re: Grading and Site Servicing Plan Review
Proposed Self Storage Development
75 Michael Cowpland Drive – Ottawa, Ontario

date: December 21, 2023

file: PG3798-MEMO.02 Revision 4

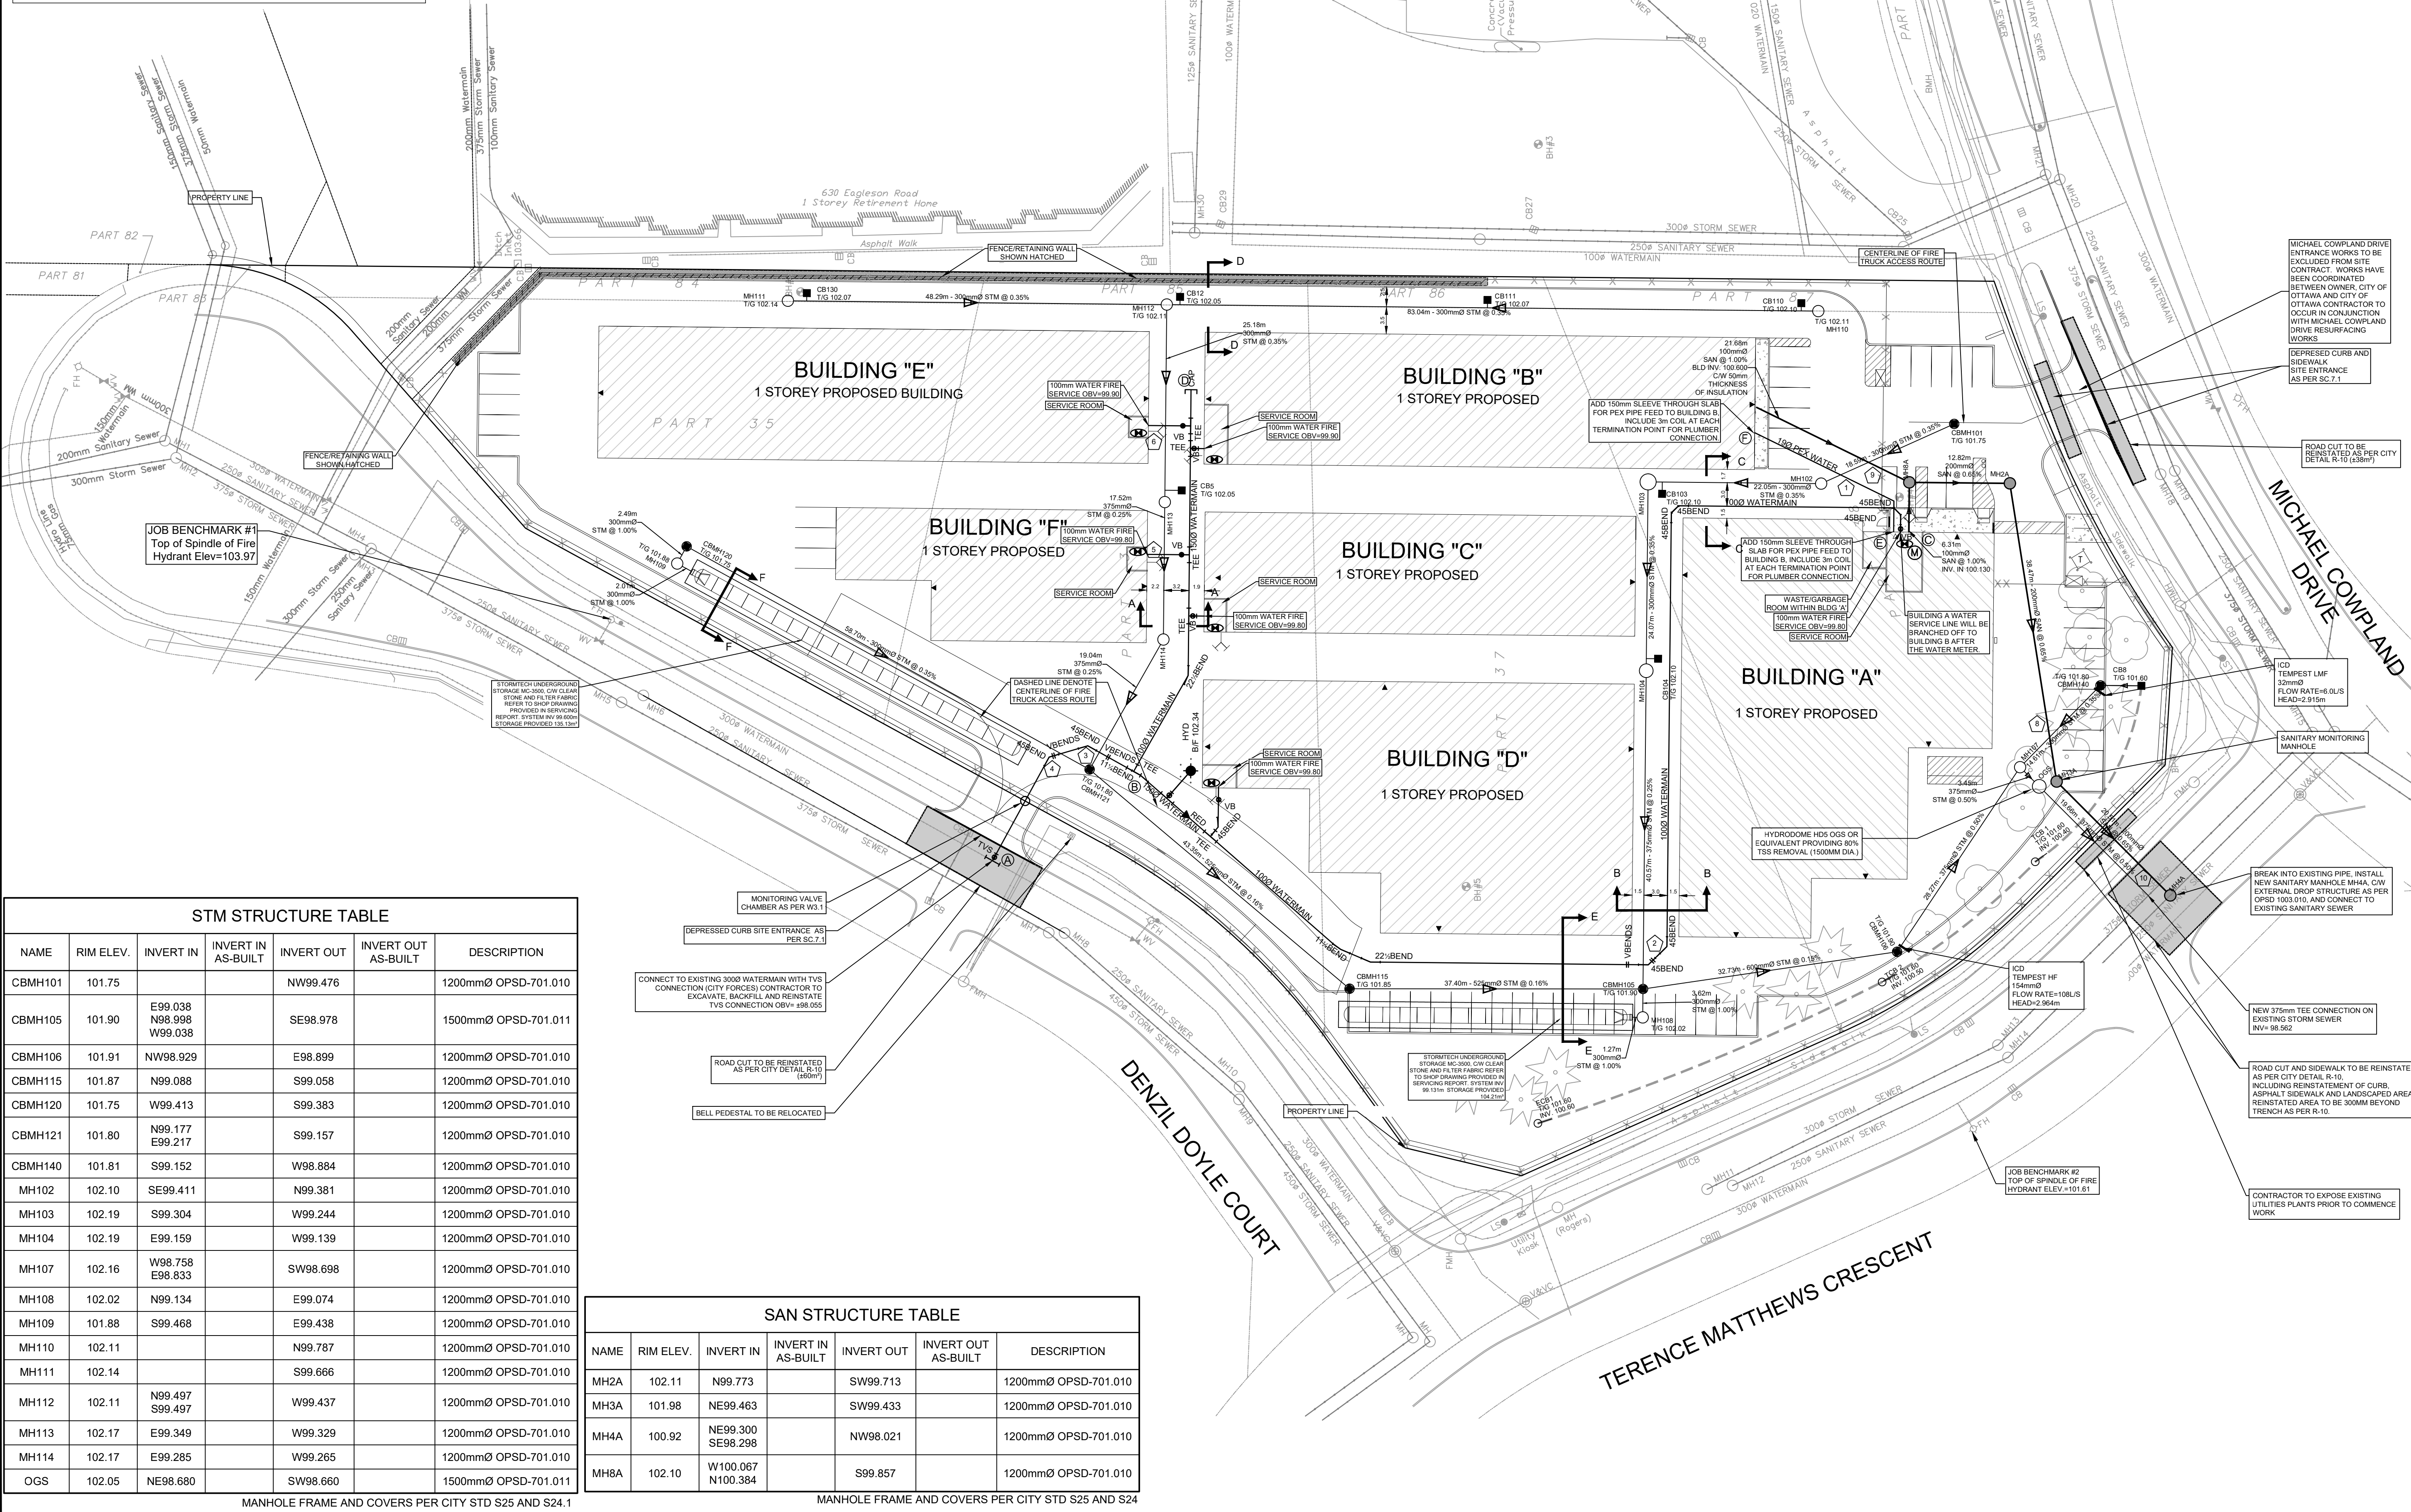
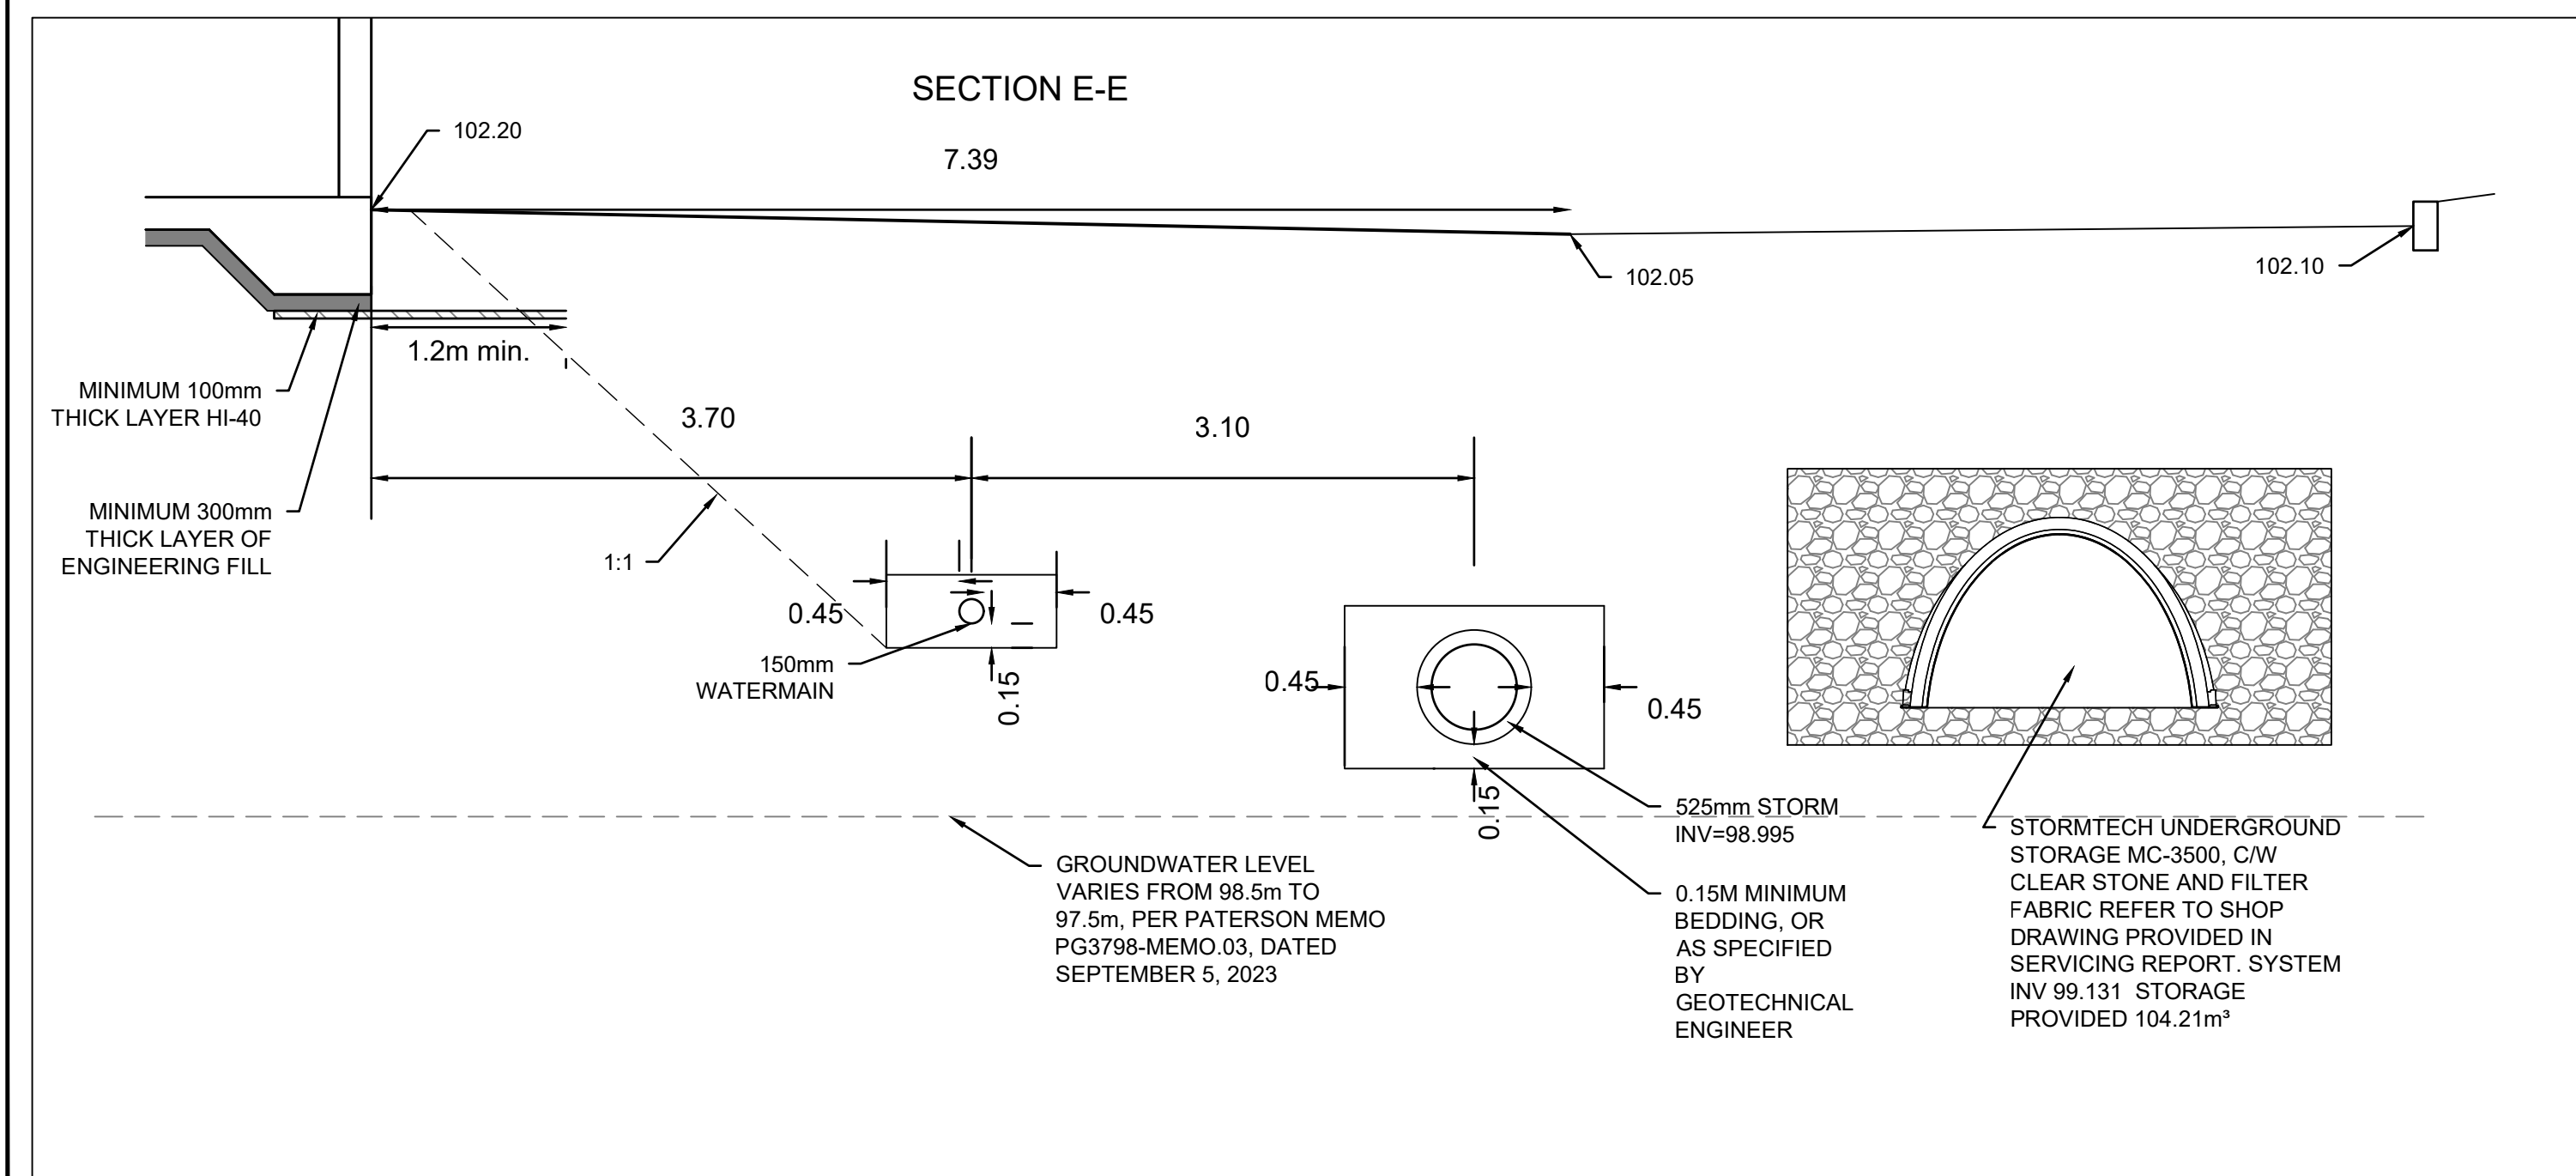
Based on our review of the above noted site service plans, the majority of the design details are considered to be acceptable from a geotechnical perspective. All proposed service pipes are sufficiently covered by adequate soil cover with no frost protection required.

Upon discussions with the design team, the proposed thickened edge slabs are now proposed to be placed on vertical, concrete in-filled trenches where adjacent service pipes are proposed with the lateral support zone of the proposed structures. These trenches would lower the lateral support zone of the slabs below the service trenches ensuring that the proposed buildings are protected should future excavation be required for the proposed services for maintenance purposes.

Due to the anticipated depth and proximity of the proposed service pipes to the proposed thickened edge slab footprints, it is expected the lateral support zones for the proposed structures will be negatively impacted by the service installation works. Further, future maintenance that could be considered throughout the proposed service alignments would require trenches that would impact the proposed buildings lateral support zones. Based on this, it is recommended to lower the lateral support zones for thickened edge footings located adjacent to impacting service alignments. This may be accomplished by sub-excavating a near-vertical trench located directly below the overlying footing footprint and in-filled with minimum 17 MPa lean-concrete.

It is recommended the near-vertical trenches extend a minimum of 150 mm horizontally beyond the overlying footing footprint. Based on our review, the lean-concrete trench detail has been incorporated satisfactorily into the above-noted site servicing plans. The recommended perimeter thickened-edge slab foundation insulation detail is depicted below for the proposed storage structures and has been incorporated satisfactorily in the above-noted site servicing plans. The placement of the lean-concrete trench and rigid insulation should be reviewed and approved by Paterson personnel at the time of construction.
